**EL PASO COUNTY PLANNING AND  
 COMMUNITY DEVELOPMENT  
 DEPARTMENT**

**STORMWATER MANAGEMENT PLAN CHECKLIST**

Revised: July 2019

SHEET: **C1.1**

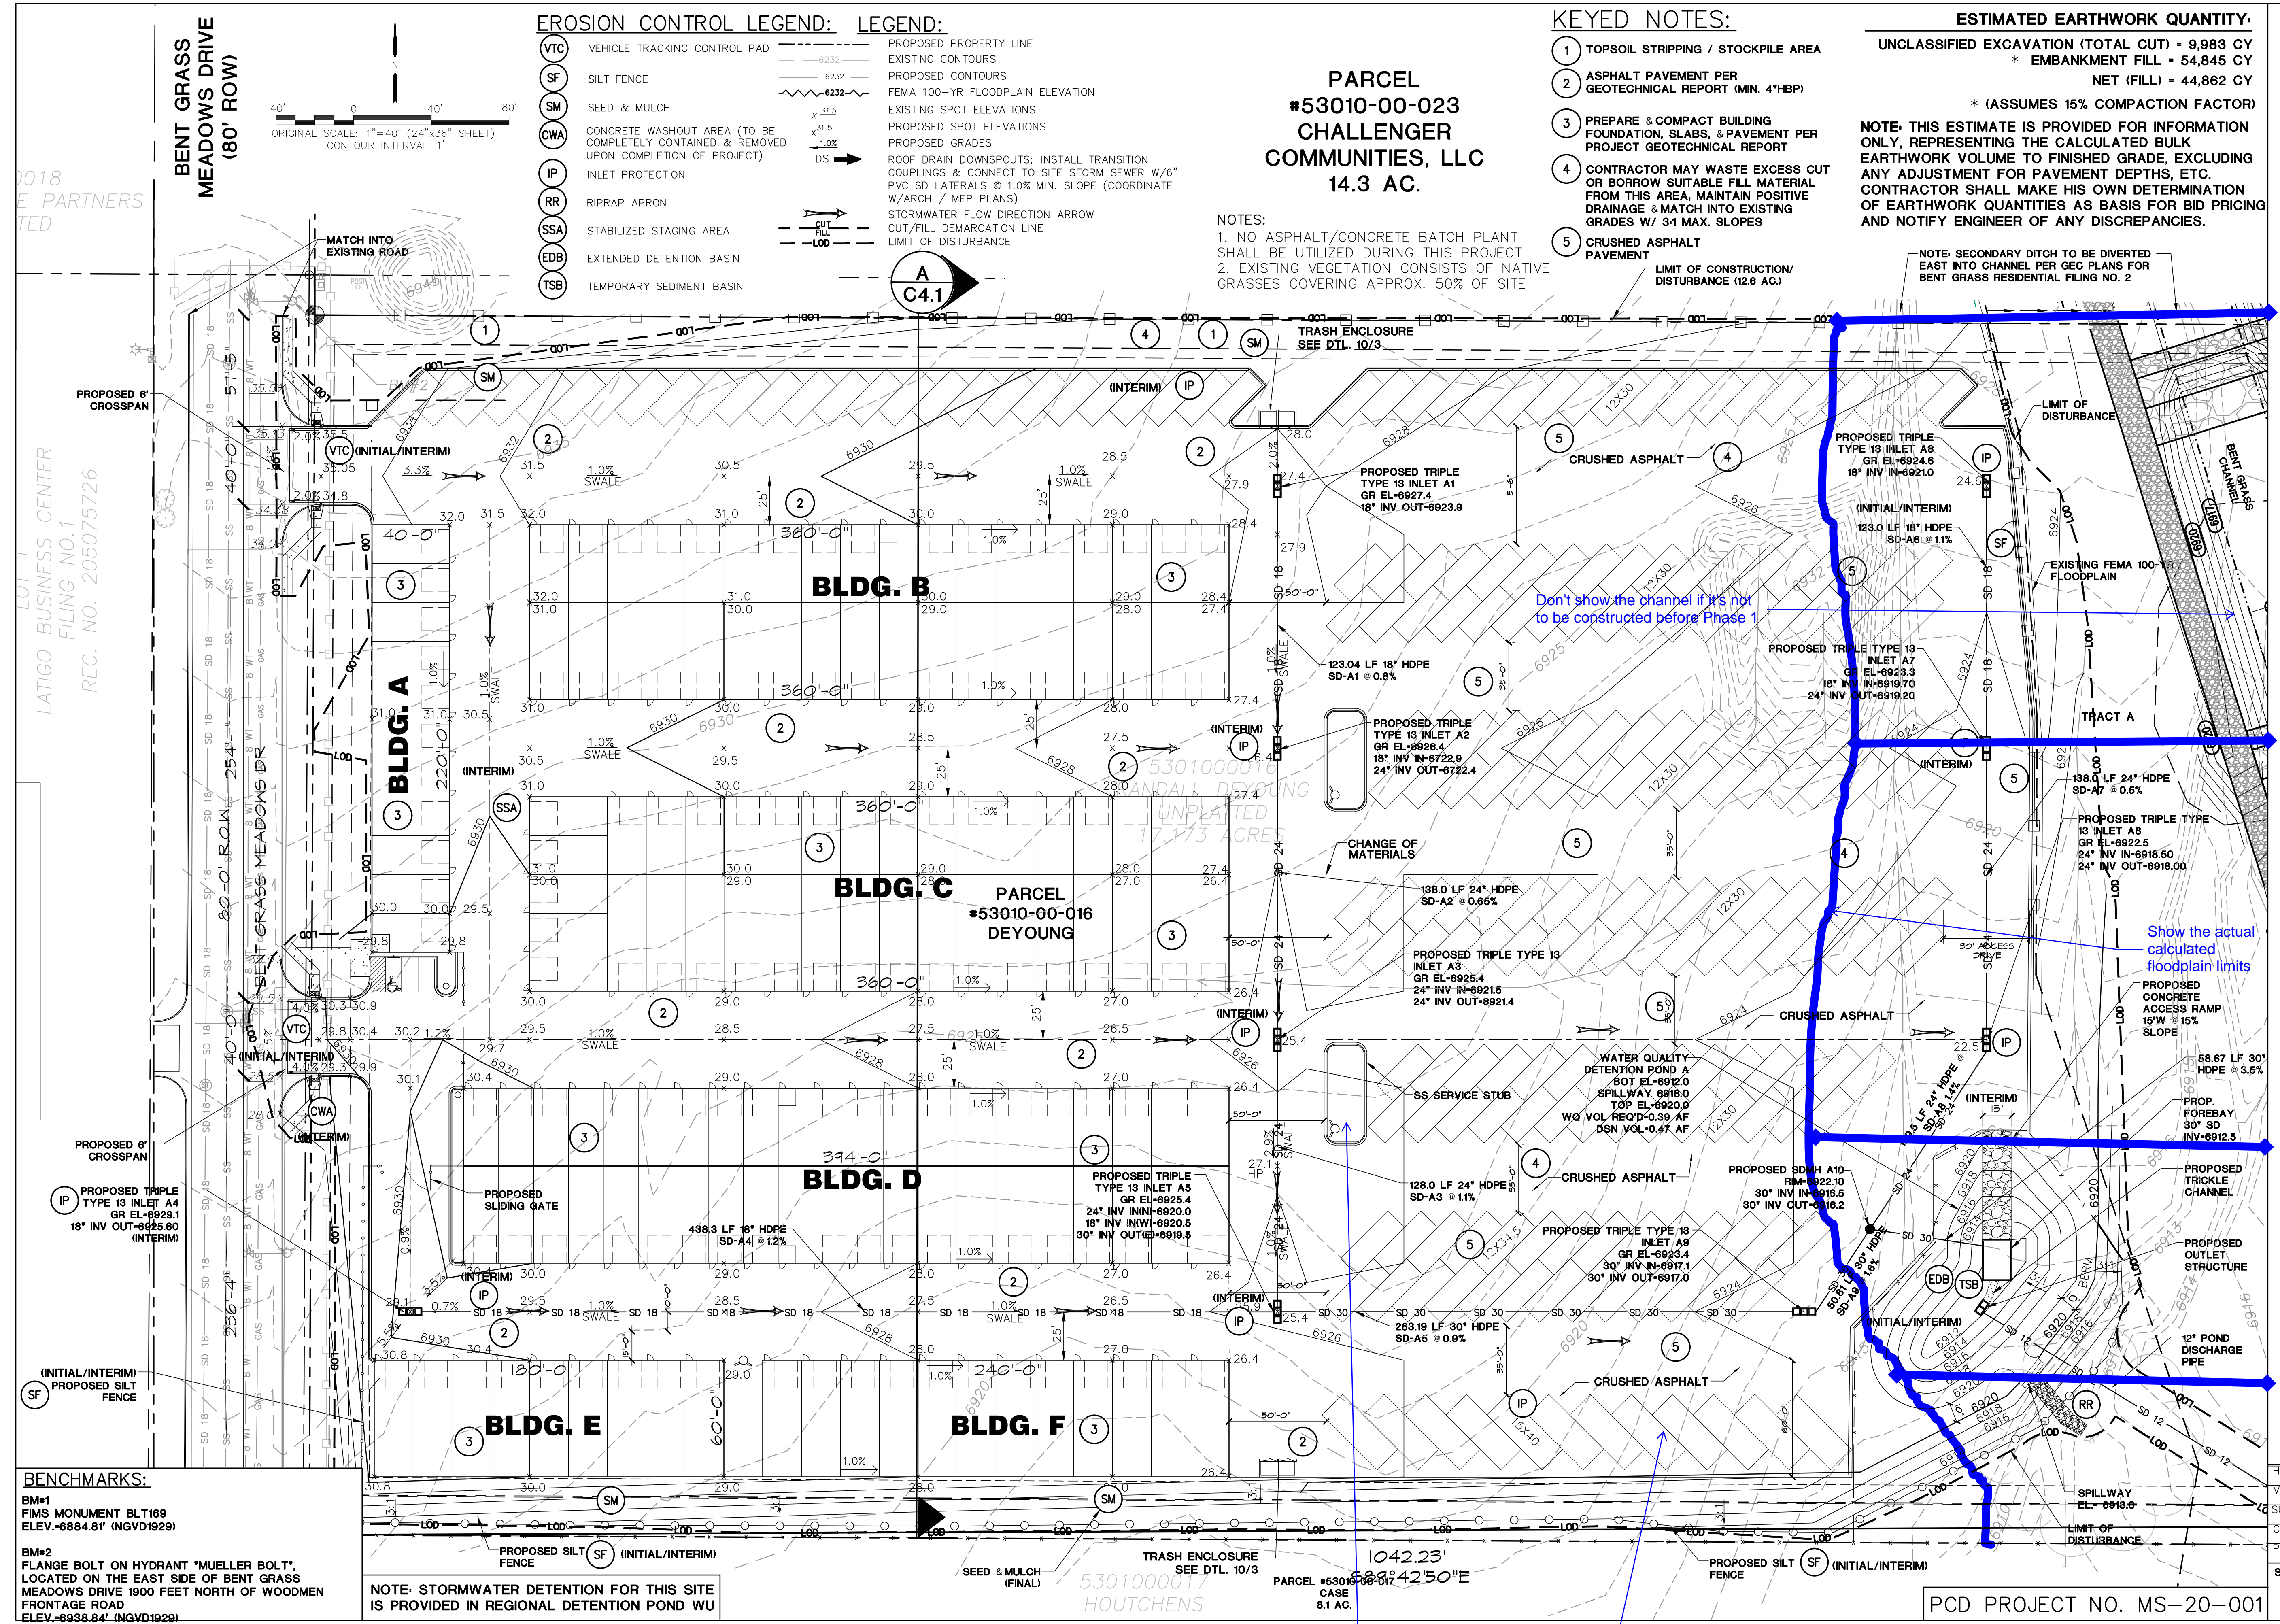
Revised: July 2019		Applicant	PCD
17	SWMP Map to include:	Y	
17a	construction site boundaries	Y	X
17b	flow arrows to depict stormwater flow directions	Y	X
17c	all areas of disturbance	Y	X
17d	areas of cut and fill	Y	X
17e	areas used for storage of building materials, soils (stockpiles) or wastes	Y	X
17f	location of any dedicated asphalt / concrete batch plants	NA	X
17g	location of all structural control measures	Y	X
17h	location of all non-structural control measures	Y	X
17i	springs, streams, wetlands and other surface waters, including areas that require maintenance of pre-existing vegetation within 50 feet of a receiving water	Y	✓
18	Narrative description of all structural control measures to be used. Modifications to EPC standard control measures must meet or exceed County-approved details.	Y	✓
19	Description of all non-structural control measures to be used including seeding, mulching, protection of existing vegetation, site watering, sod placement, etc.	Y	✓

20	Technical drawing details for all control measure installation and maintenance, custom or other jurisdiction's details used must meet or exceed EPC standards	Y	X
21	Procedure describing how the SWMP is to be revised	Y	✓
22	Description of Final Stabilization and Long-term Stormwater Quality (describe nonstructural and structural measures to control SW pollutants after construction operations have been completed, including detention, water quality control measure etc.)	Y	✓
23	Specification that final vegetative cover density is to be 70% of pre-disturbed levels	Y	✓
24	Outline of permit holder inspection procedures to install, maintain, and effectively operate control measures to manage erosion and sediment	Y	✓
25	Record keeping procedures identified to include signature on inspection logs and location of SWMP records on-site	Y	✓
26	If this project relies on control measures owned or operated by another entity, a documented agreement must be included in the SWMP that identifies location, installation and design specifications, and maintenance requirements and responsibility of the control measure(s).	Y	✓
